Wansford Parish Council

Deadline 4 Submission

Traffic Modelling of the Wansford Western Roundabout

A47 Wansford to Sutton Dualling

Figure 2.1: Layout of the A47/A1 Western roundabout

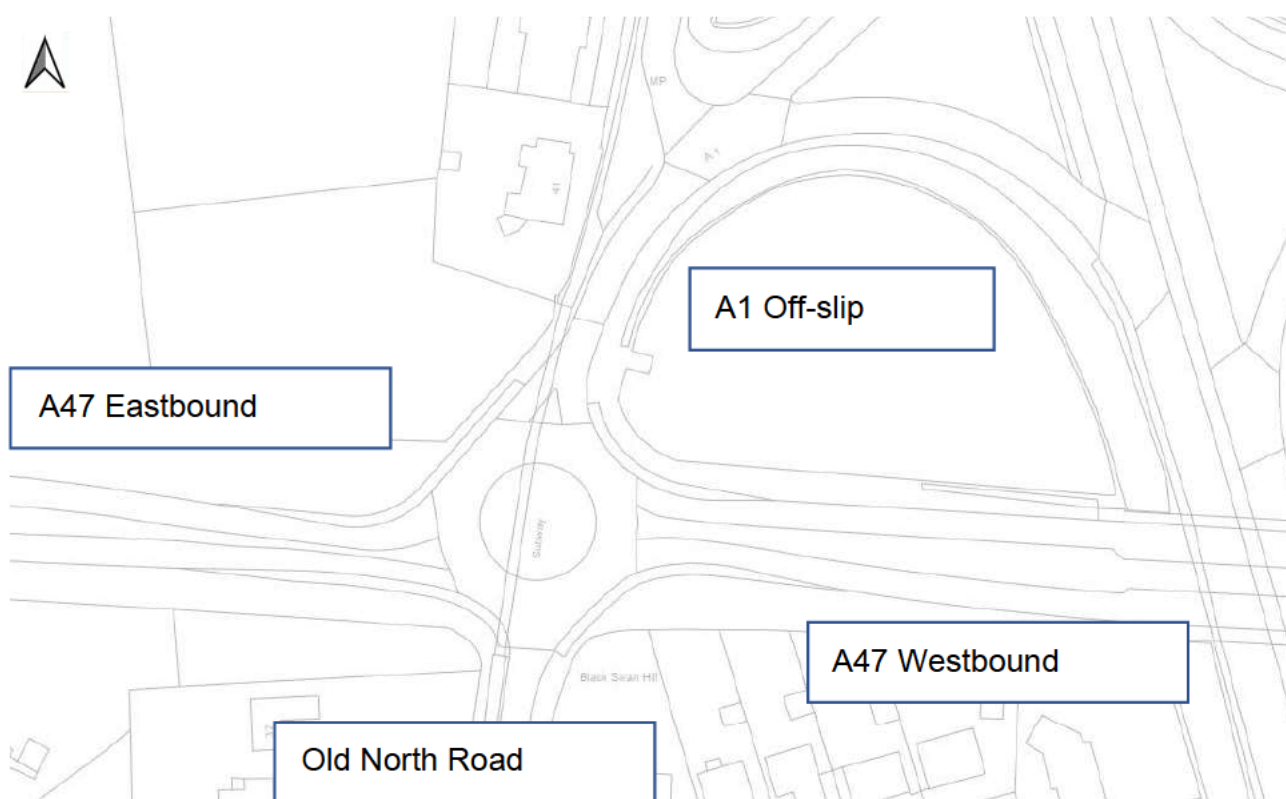
In Issue Specific Hearing 3, the Examining Authority raised the matter of the modelling of the traffic flows on the Wansford Western Roundabout. He correctly observed that the actual measured 2019 traffic flows northbound on Old North Road did not correspond to the flows predicted by the traffic model. When National Highways (NH) were challenged on this, they seemed to respond that the results of the modelling had to be accepted even though they did not match reality.

In their earlier submission, NH claimed that adding an additional exit lane eastbound from the western roundabout would improve the flow by giving more spaces for vehicles exiting Old North Road. In reality the opportunities to exit Old North Road are the result of gaps in the flow of traffic entering the roundabout westbound and gaps in the flow entering the roundabout from the A1 and then heading westbound. Neither of these flows is influenced by the eastbound exit lanes.

Numerically the main delays on the western roundabout are to vehicles entering the roundabout heading east along the A47. This flow is interrupted by vehicles arriving westbound on the A47 and then heading north up the A1 and by traffic leaving Old North Road and either going north or east, as the majority of it does.
